**WEST SUSSEX COUNTY COUNCIL
STRATEGIC PLANNING CONSULTATION**

SUBJECT: LU/5/12 - Erection of 1 x 3 bed town house.

Land rear of 27-29B, Surrey Street, Littlehampton, West Sussex, BN17 5BD

## BLOCK PLAN

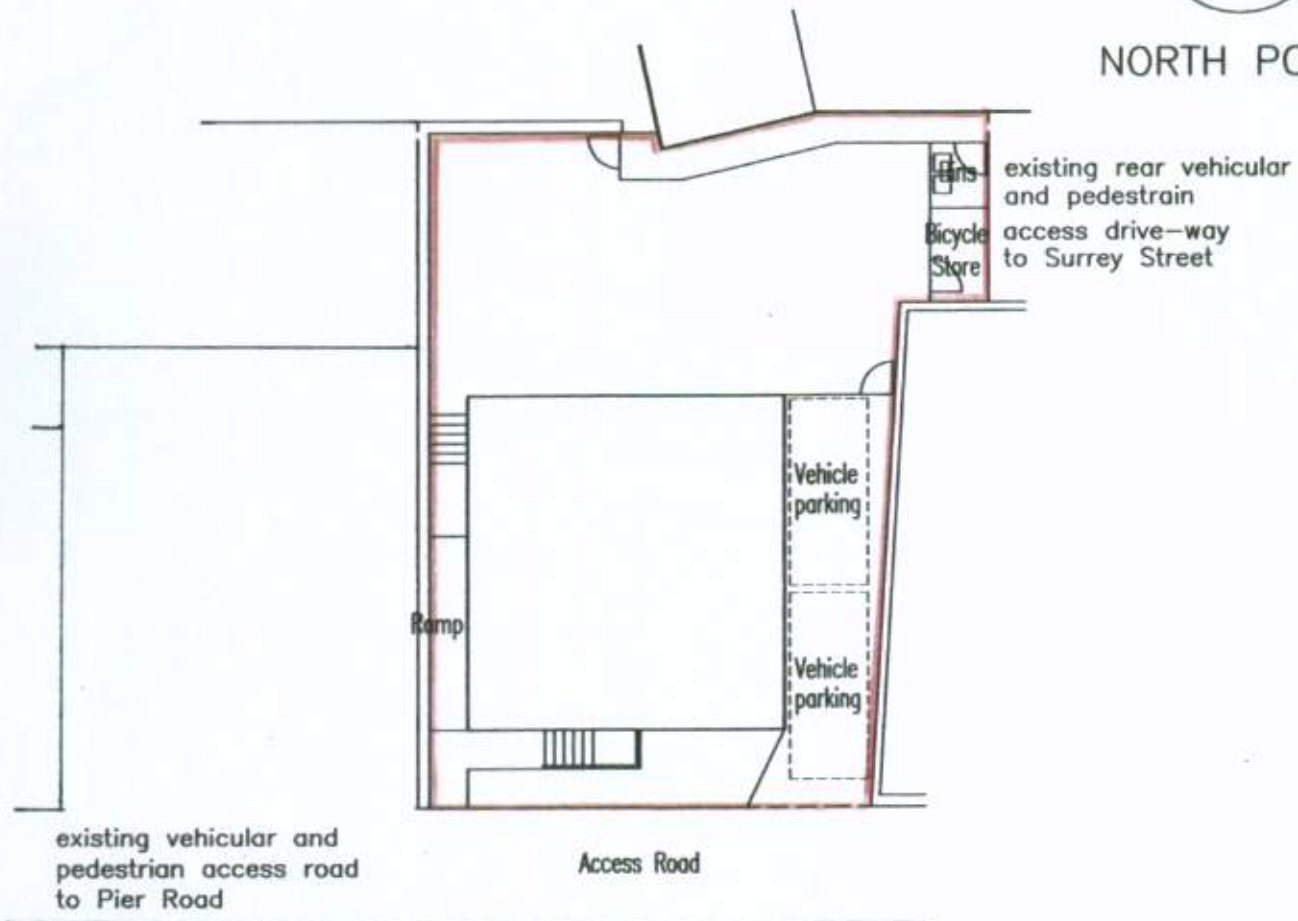
I can confirm that the proposed 2 parking spaces are acceptable for a development of this size in this location, with regard to the latest WSCC appropriate level of car parking standards. Secured and covered cycle parking is included and should be secured via condition. It does not appear from the plans provided that a turn on site will be possible; however a turn utilising the private access road would probably be achievable.

If the LA are minded to approve this application, conditions securing vehicular and cycle parking should be included.
